**RE: McDonald's at Ventana Square
Grading and Drainage Plans
Engineer's Stamp Date: 07/07/23
Hydrology File: B10D003C3B**

Based upon the information provided in your submittal received 07/11/2023, the Grading & Drainage Plans **are not** approved for Building Permit and Grading Permit. The following comments need to be addressed for approval of the above referenced project:

PRE DEV. DRAINAGE MAP AND CALCULATIONS

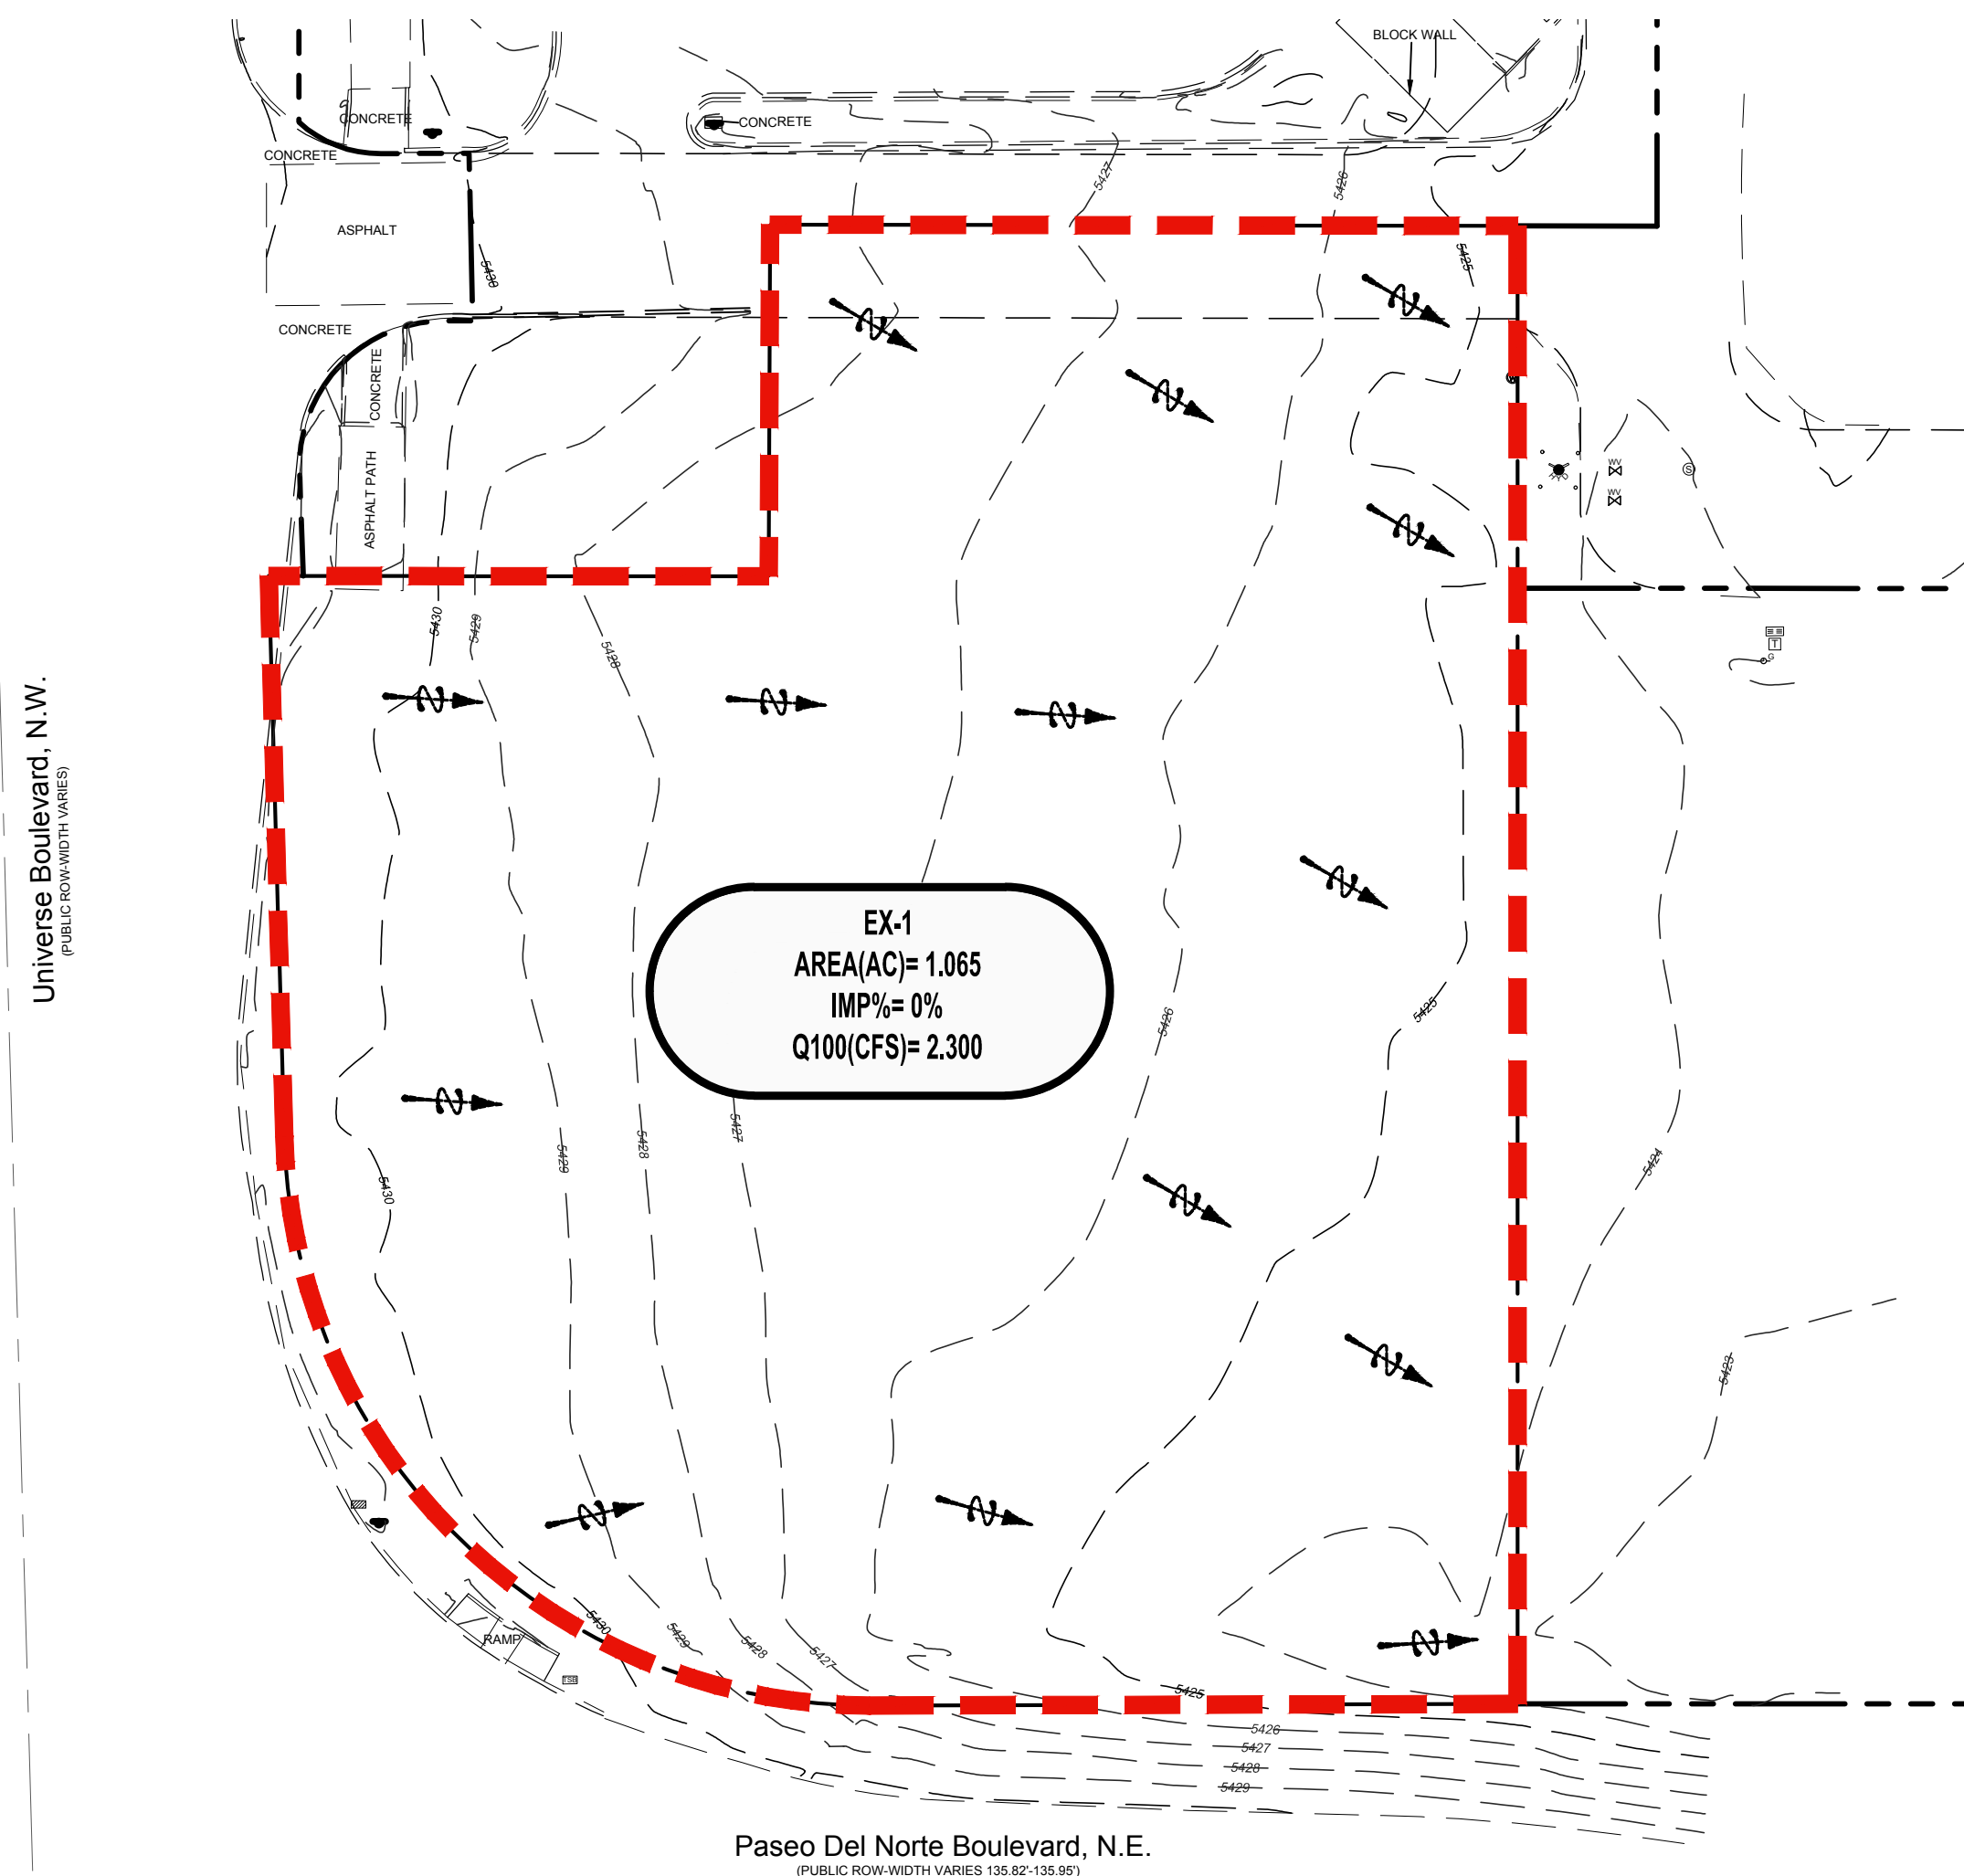
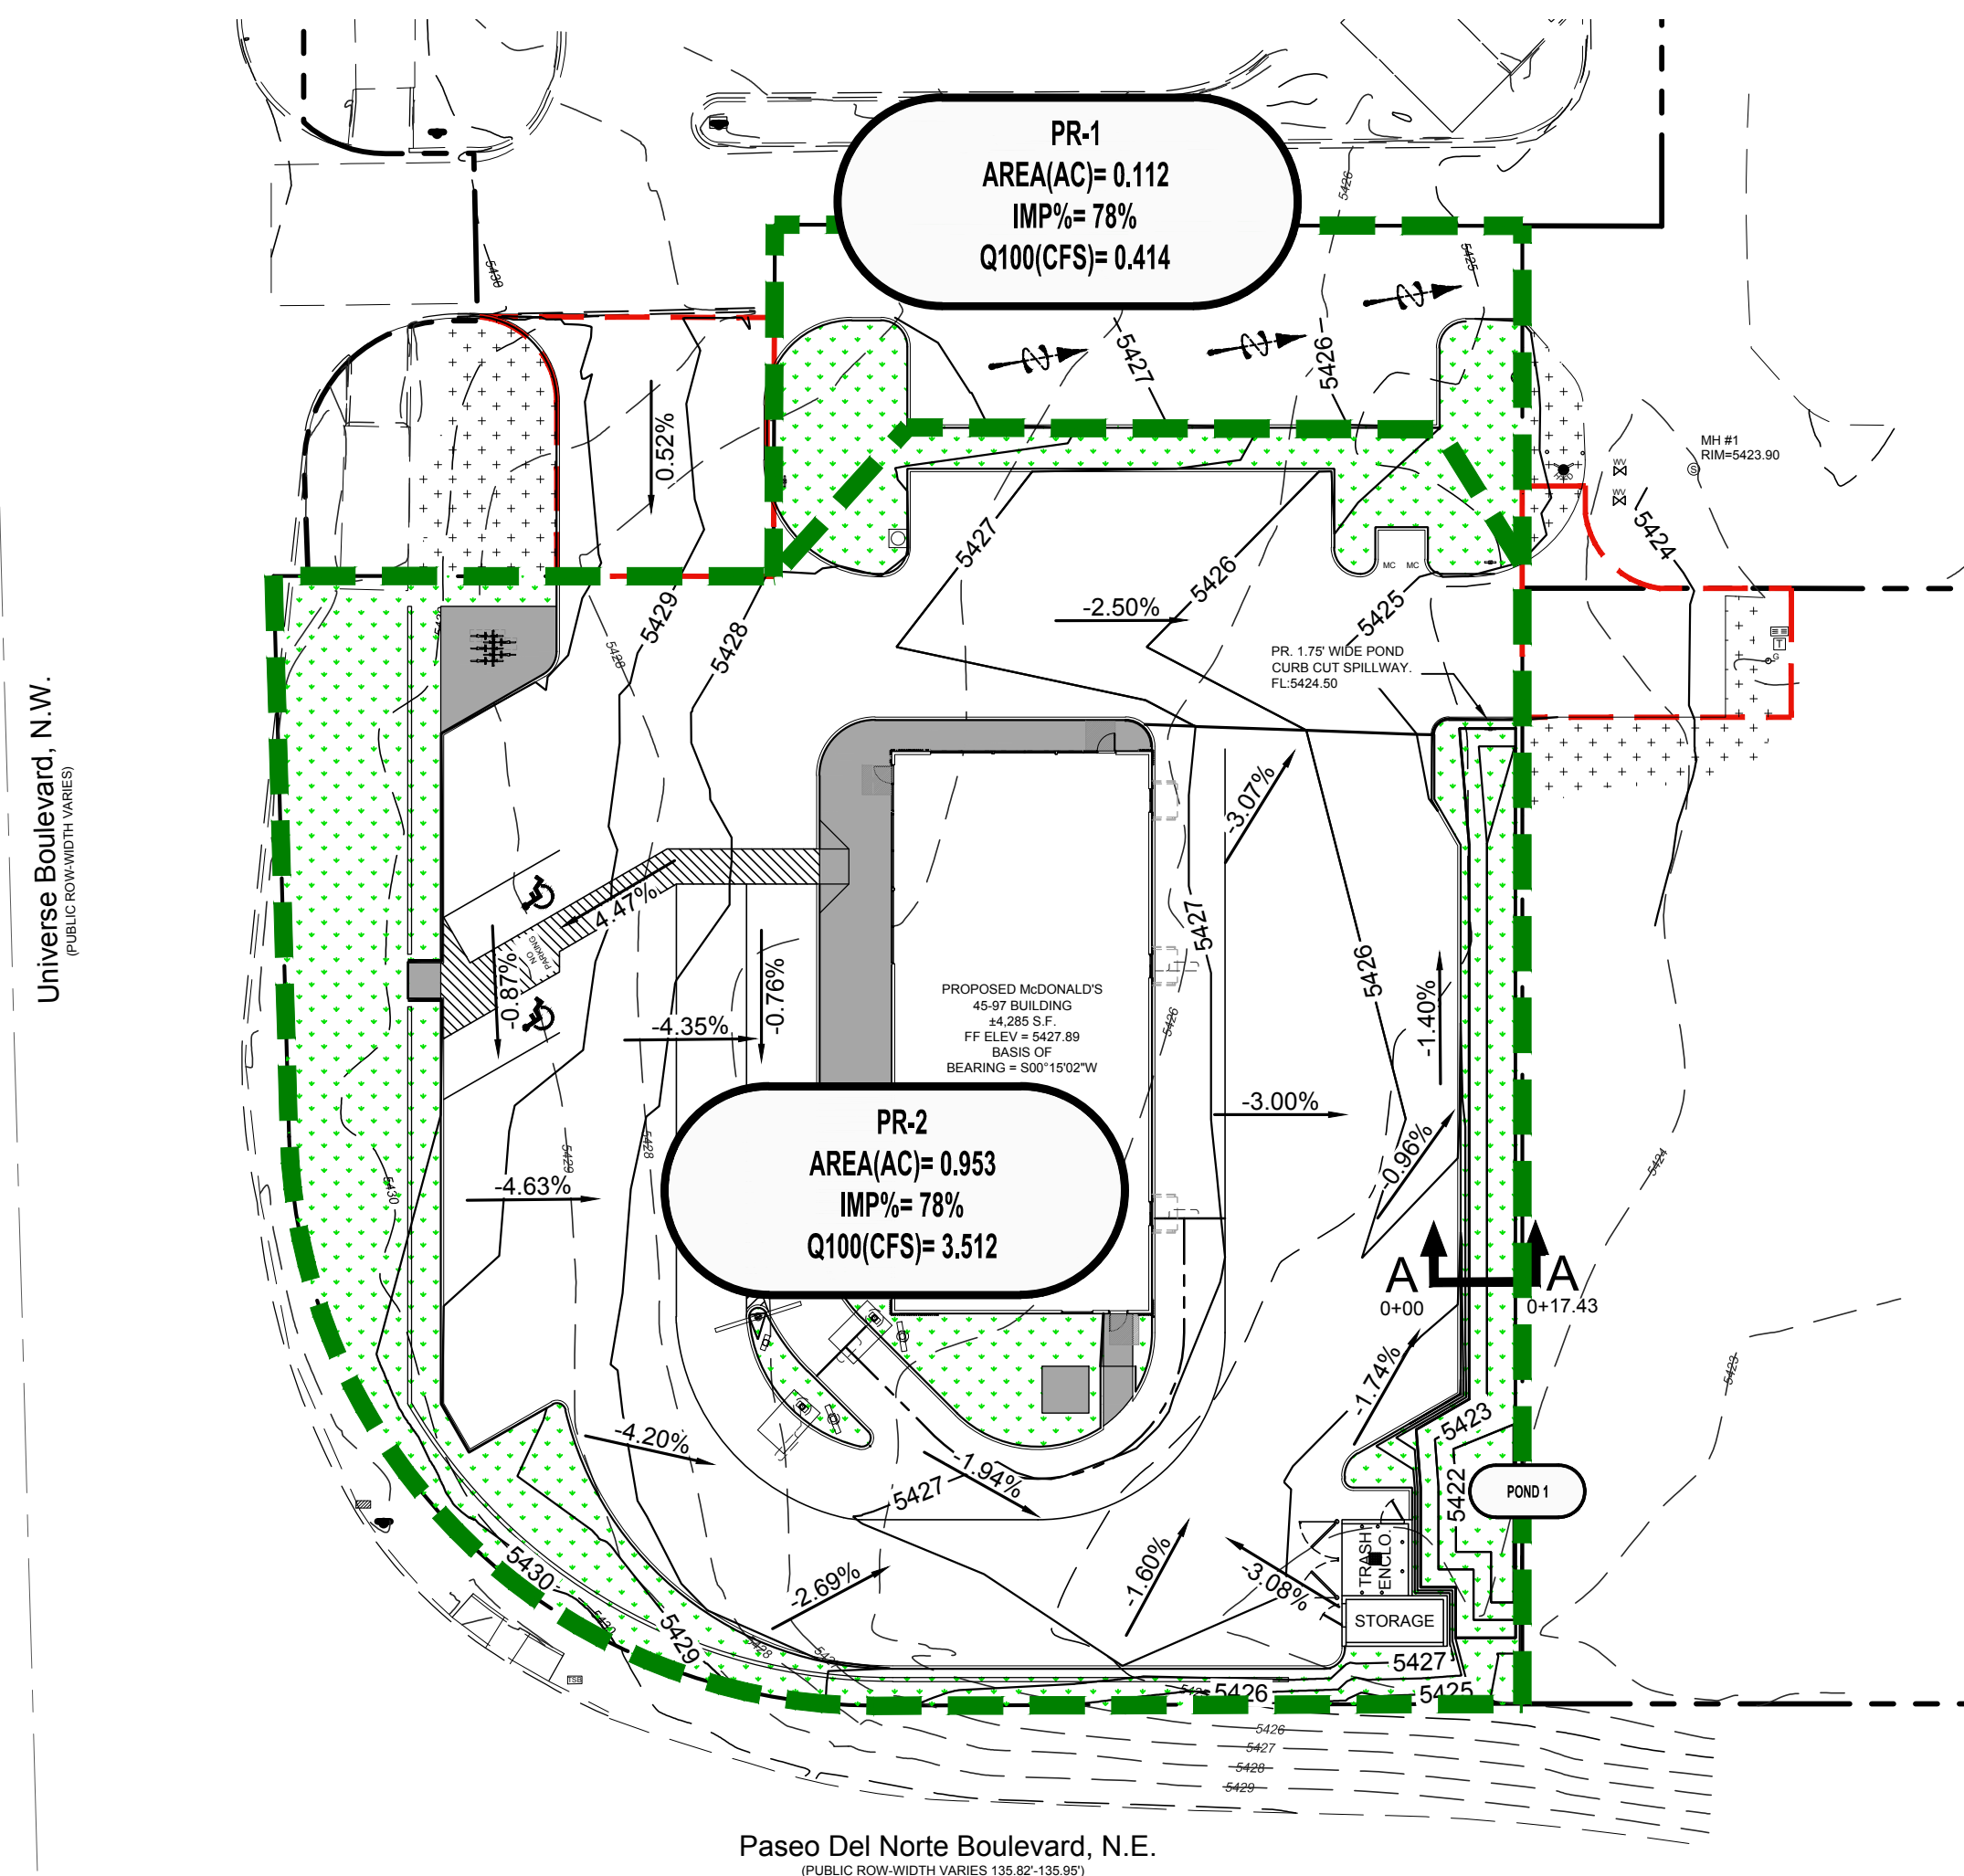
- Sheet C8.0. Please add a not in the Existing Conditions or Proposed Conditions that this site is within the Ventana Square Drainage Master Plan and that this site has an allowable discharge of 4.48 cfs. I have attached the approved Ventana Square Drainage Master Plan for your use.

- Sheet C8.0. Please use the procedure for 40 acre and smaller basins as outlined in Development Process Manual (DPM) Article 6-2(a). Please provide both the existing conditions and proposed conditions for the 100 year-6 hour storm event. The approved Ventana Square Drainage Master Plan has a great example of these calculations.
